RFI

RFI #: 25
 Date: 1/5/2012
 Job: EB-02 Keller Springs Lofts
 Phone: 877-777-5115

CC:
 Subject: L shaped rebar dowels

SG3.02

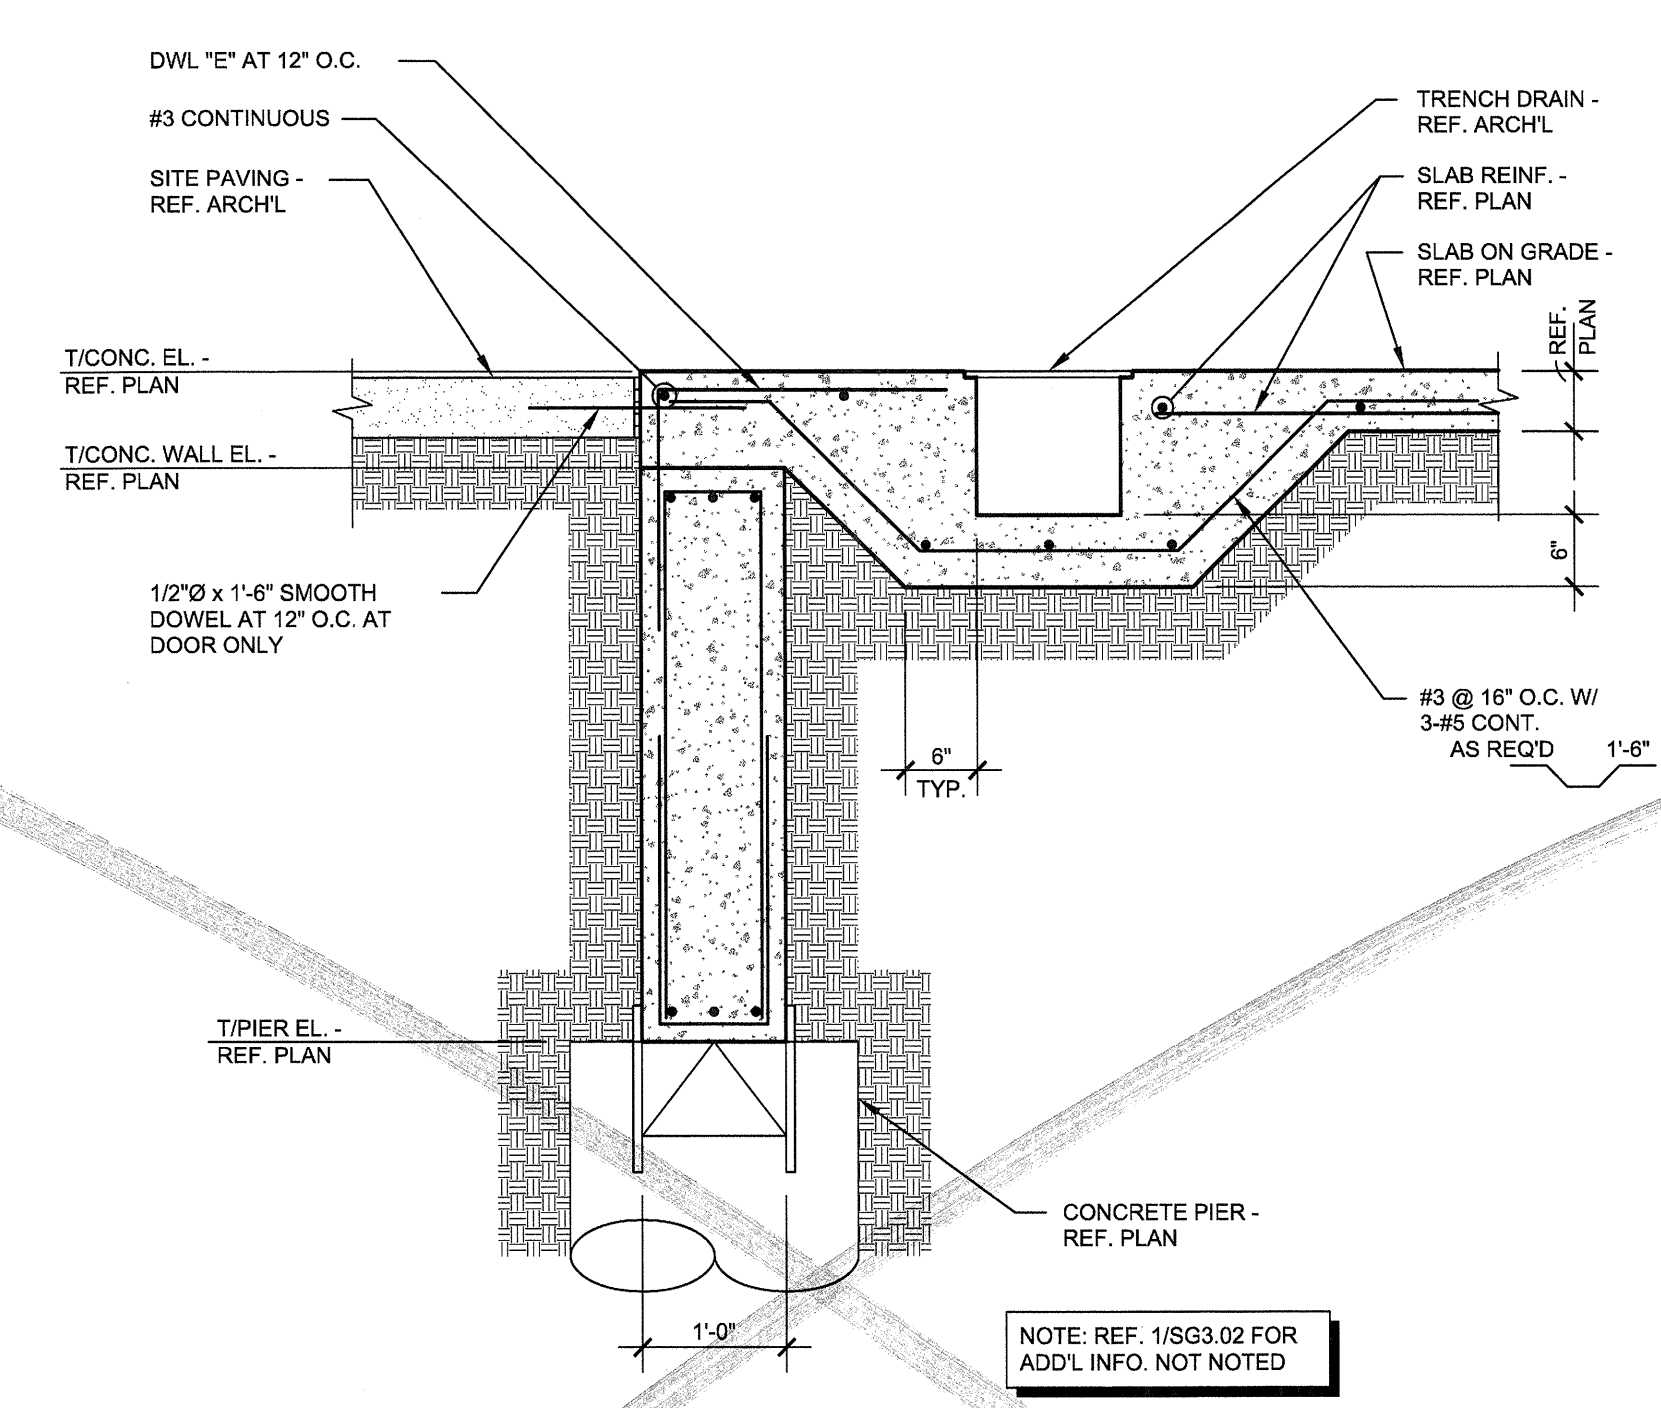
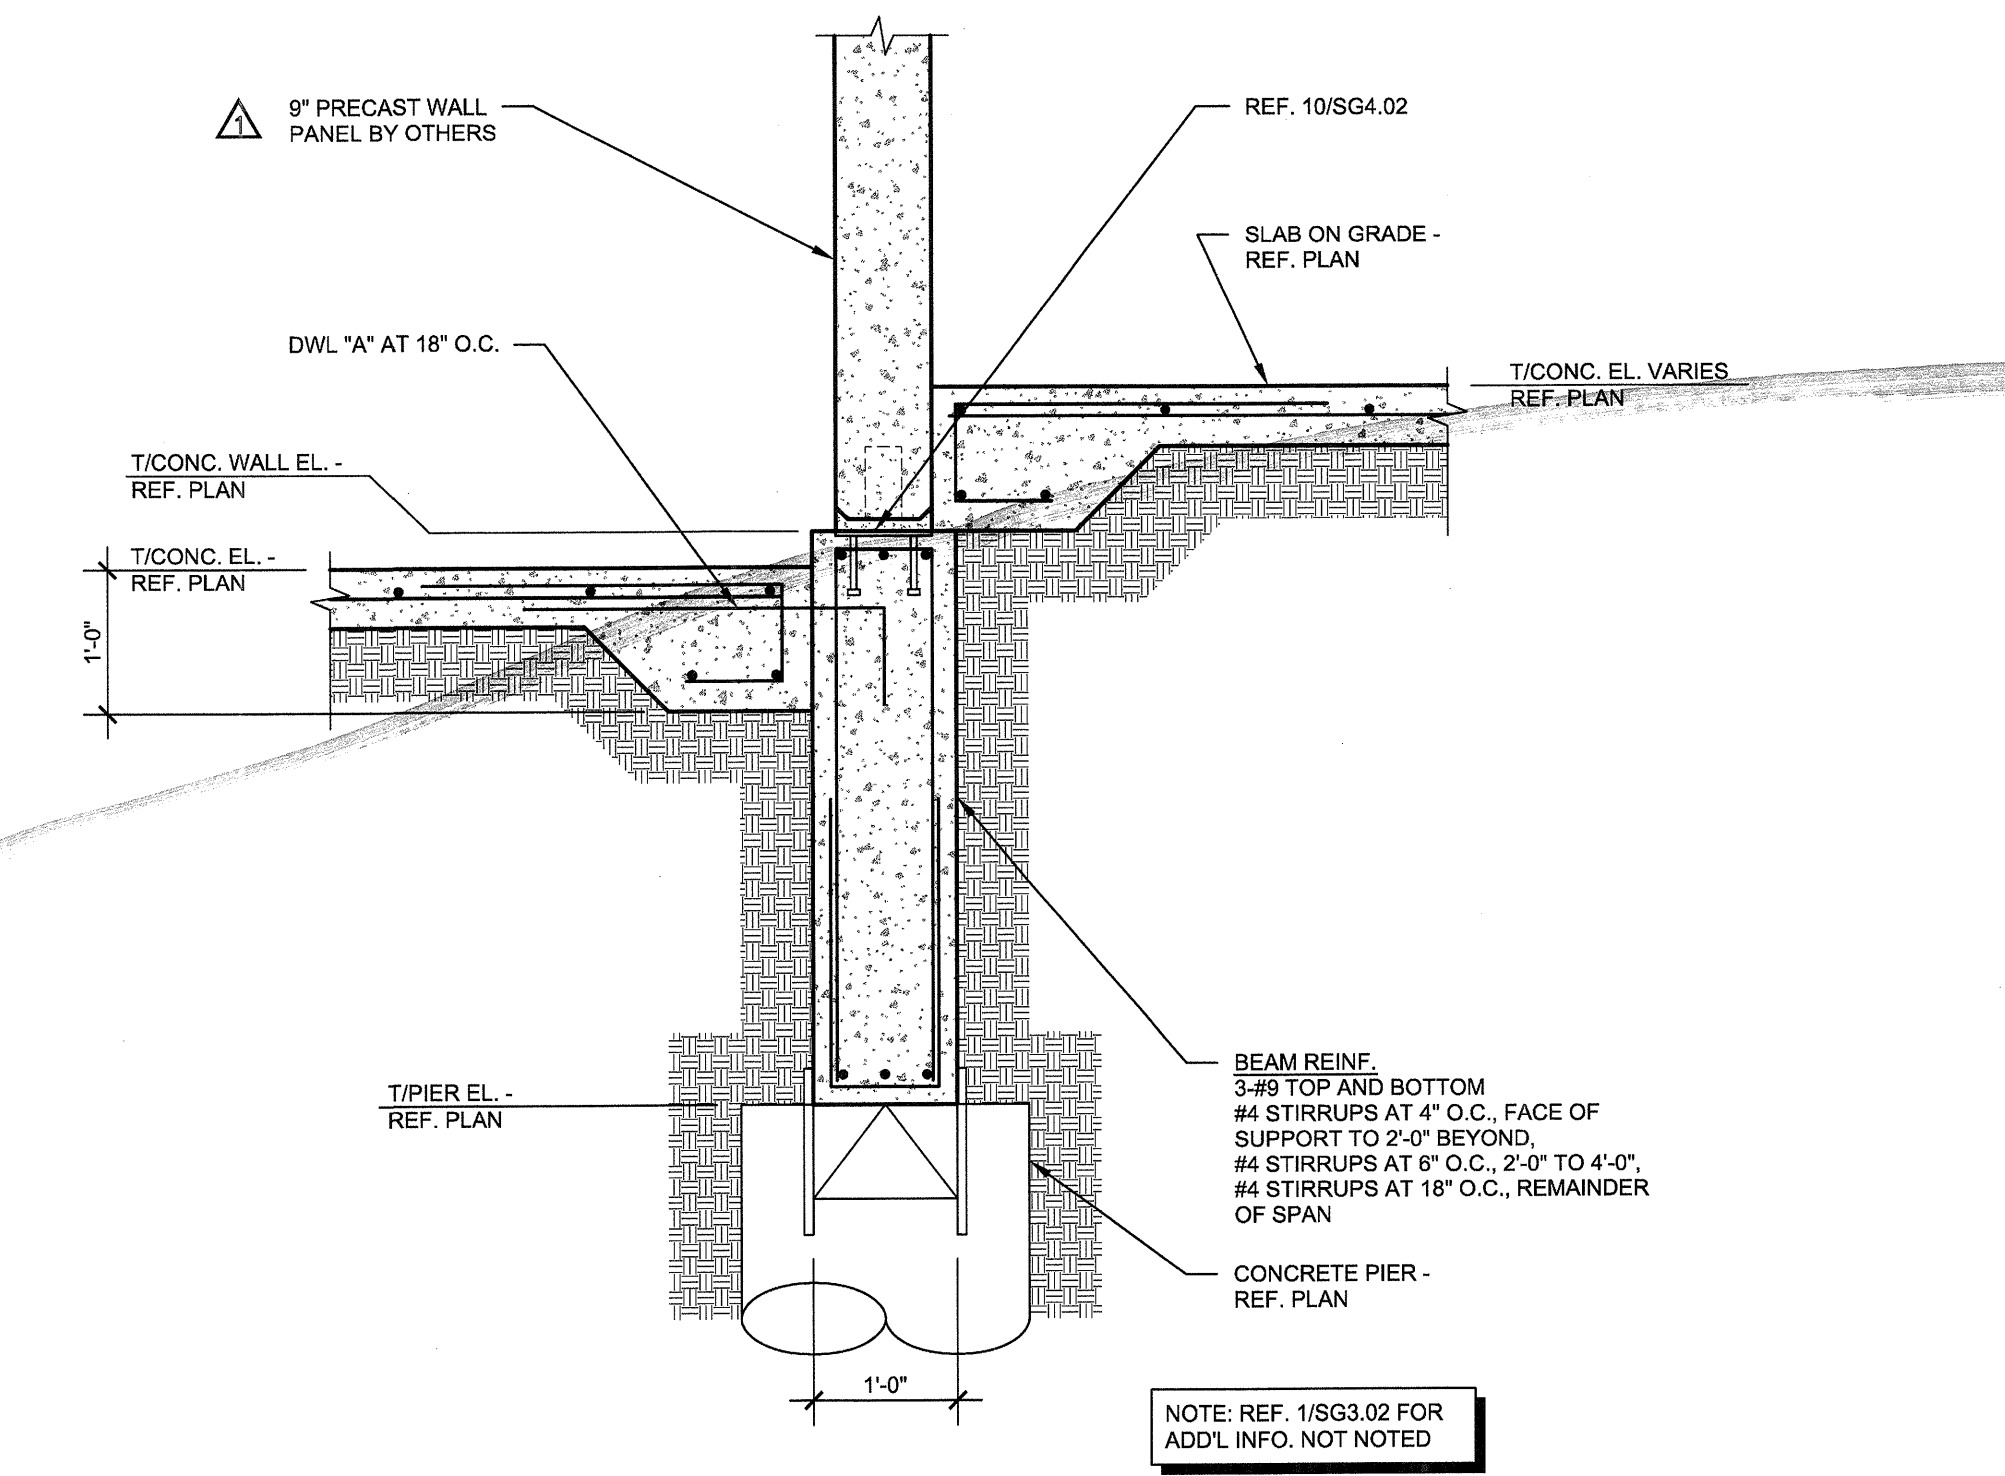
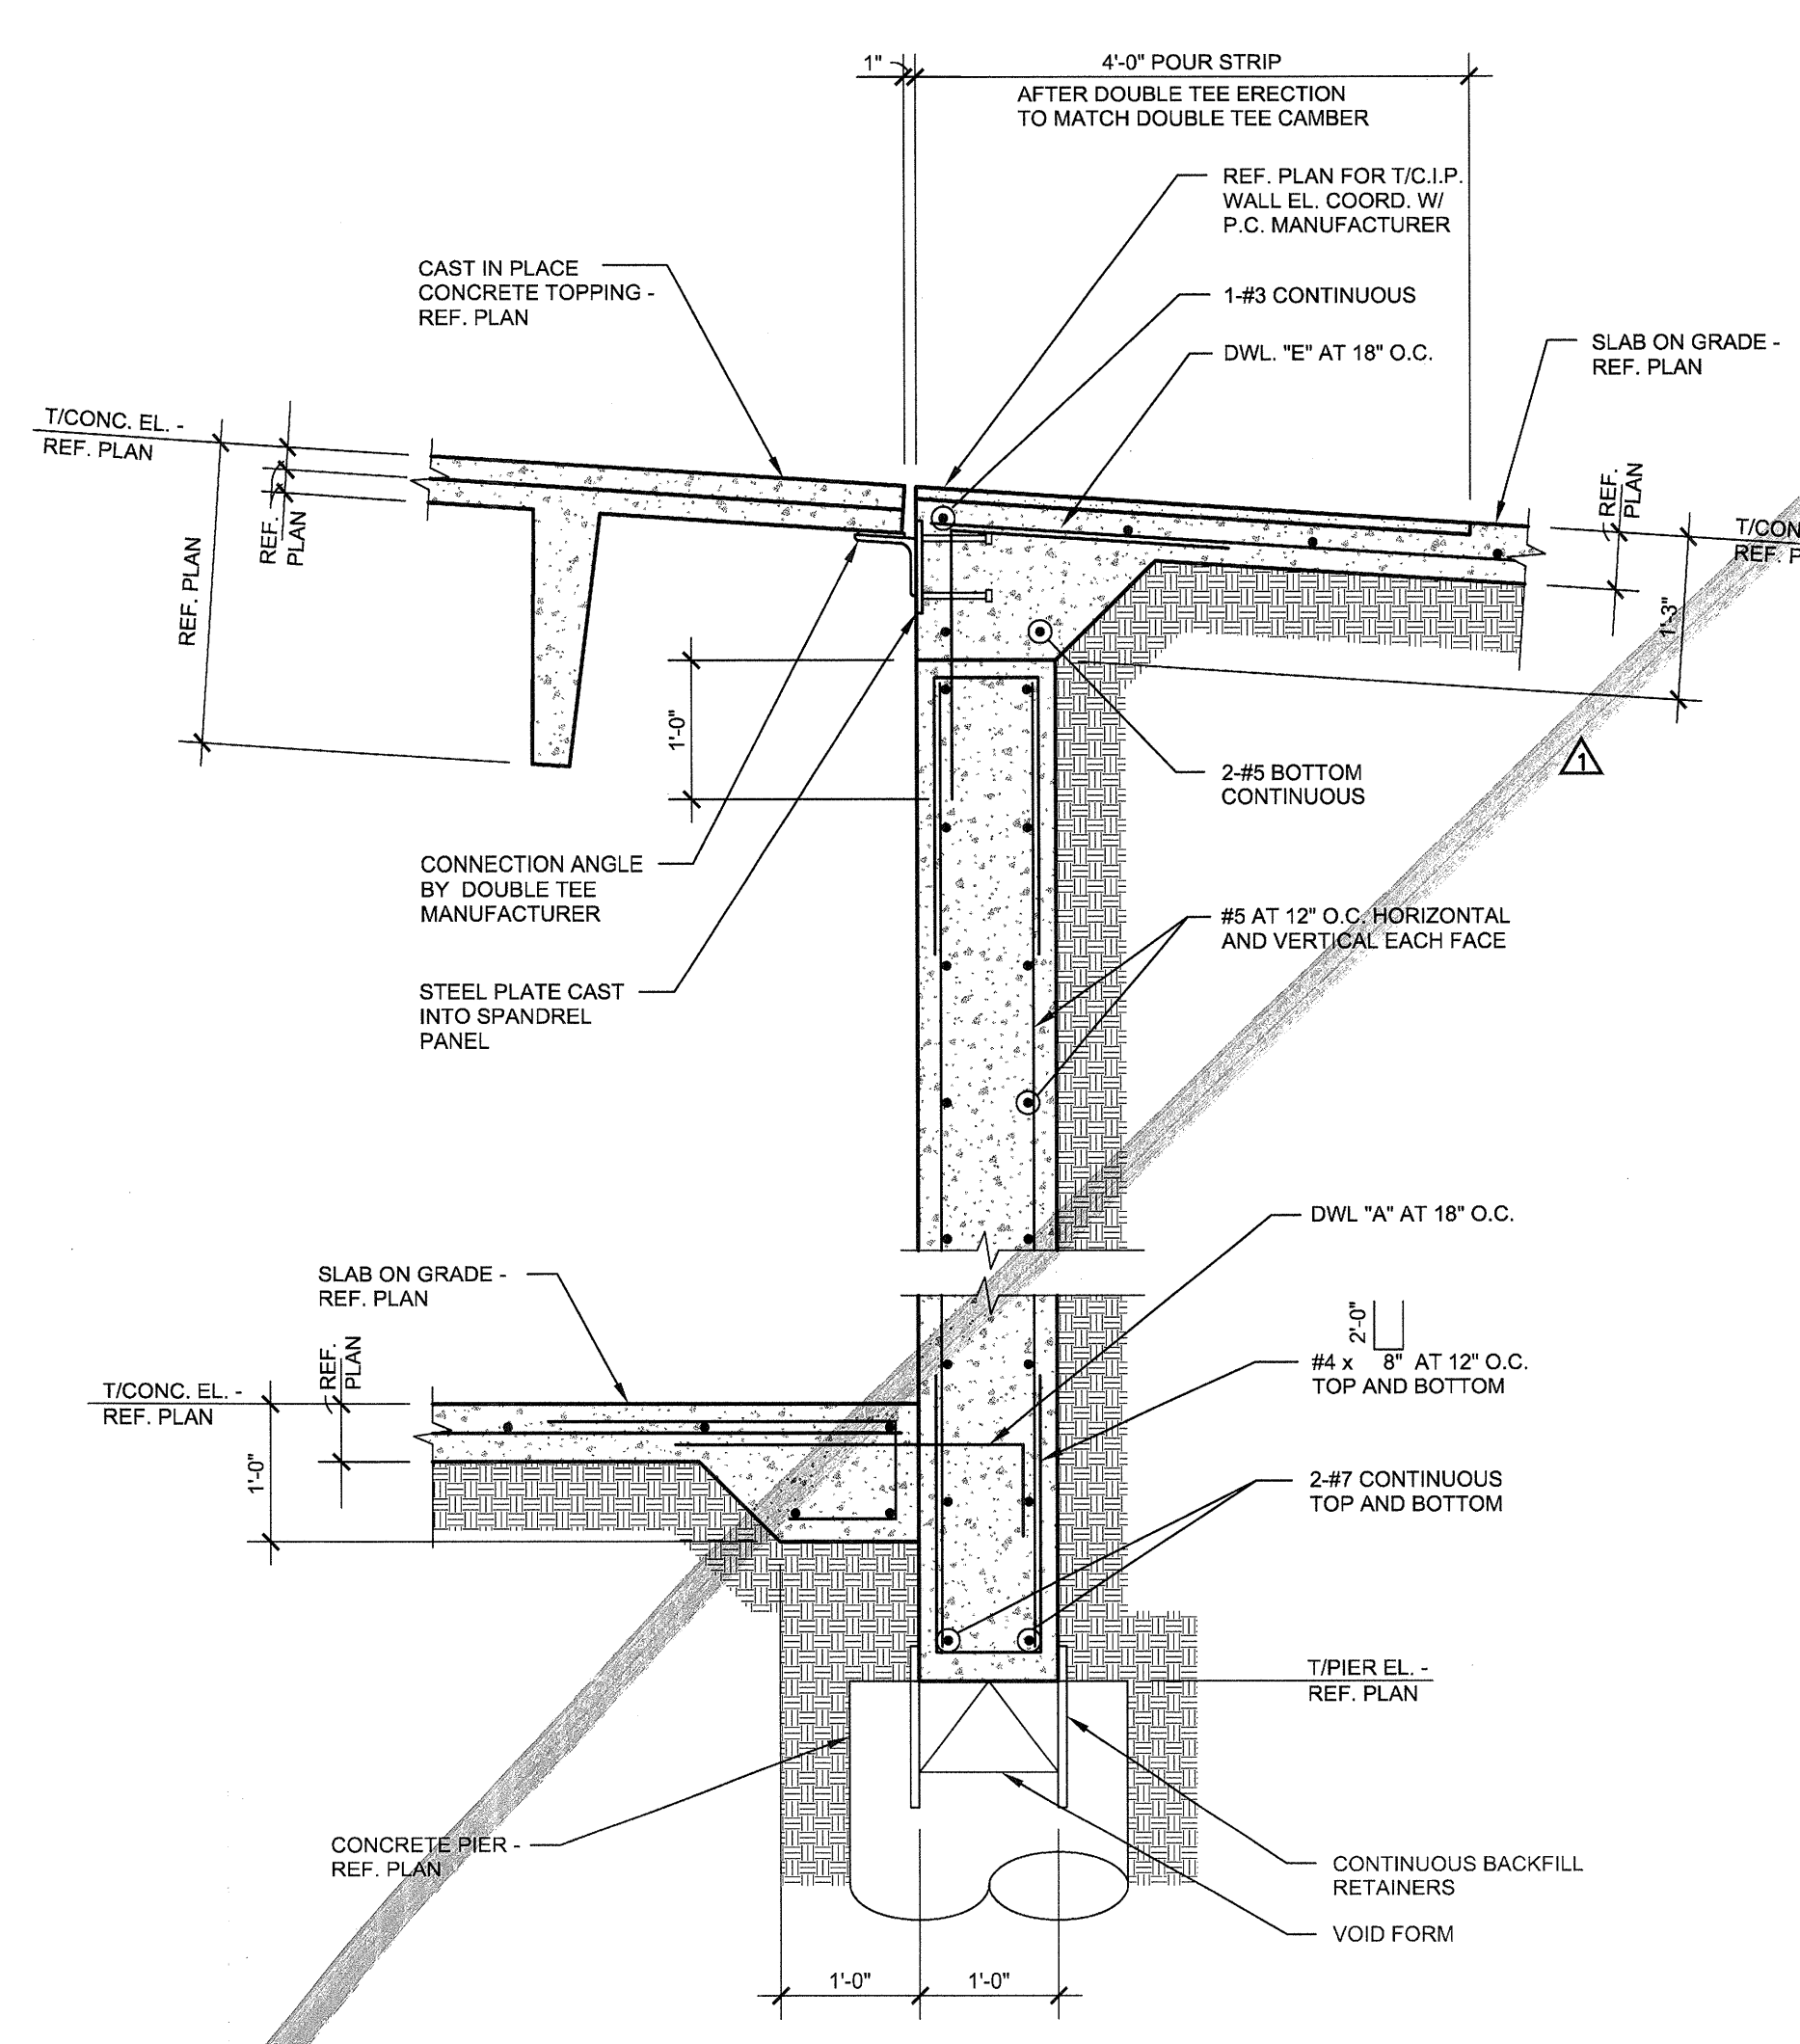
Request:
 Detail 4/SG3.02 and 5/SG3.02 shows rebar dowels from beam walls to the F.F. slab of garage floor. Since the beam walls are formed and poured 1st we will not be able to install dowel bar 1st. We would have to destroy the panels if we did. Can we pour the walls 1st and then come back and drill and epoxy the dowel later. Please give us the required information for the depth of drilled dowels and epoxy strength required. Also do you want them to be L-bar with the L side in the slab?
 Date Required: 1/12/2012

Request:
 Is 3/SG3.02 the correct detail @ intersection of grid line 6 + B?
 Date Required: 1/12/2012

Request:
 Detail section 1/SG3.02 shows a 1" thickend beam which partially abuts to the pre-cast panel and beam wall. However, typical T.O.W elevation is 1' below the typical top of F.F. for garage slab. Therefore the beam and the pre-cast panel will be recessed 1" from top of F.F. garage and several feet from top of F.F. of building slab. Please advise
 Date Required: 1/12/2012

Request:
 As previously discussed, there was a question in regards to the number of L-bars from top of pier and into the pier cap. Our concrete man felt that detail 3/SG3.02 was calling for (2) #7 L-bar dowels (one on each side of column). We found out there were six L-bars supposed to be coming from the pier cap. What is the fix for the piers already poured?
 Date Required: 2/16/2012

Response:
 It is acceptable to drill and epoxy grout the dowels. Dowels shall be the same size indicated on the drawings and a minimum of 2'-0" in length. The embedment shall be 6" minimum. Adhesive shall be in accordance with the Adhesive and Drill-In Anchor Notes on sheet S1.01 of the structural drawings. The L-bars may be used; however, straight bars are acceptable.
 If you have questions or require additional information regarding this matter, please do not hesitate to contact us.

Response:
 Please refer to revised drawings issued on January 25, 2012. If you have questions or require additional information regarding this matter, please do not hesitate to contact us.

Response:
 Refer to structural drawings issued on January 4, 2012.
 If you have questions or require additional information regarding this matter, please do not hesitate to contact us.

Response:
 Drill and grout in additional dowels as required utilizing Simpson SET adhesive with a minimum of 13 1/8" of embedment in accordance with the recommendations of the manufacturer.
 R. Trent Perkins, P.E.
 Parkin-Perkins-Olsen Consulting Engineering, Inc.
 February 15, 2012
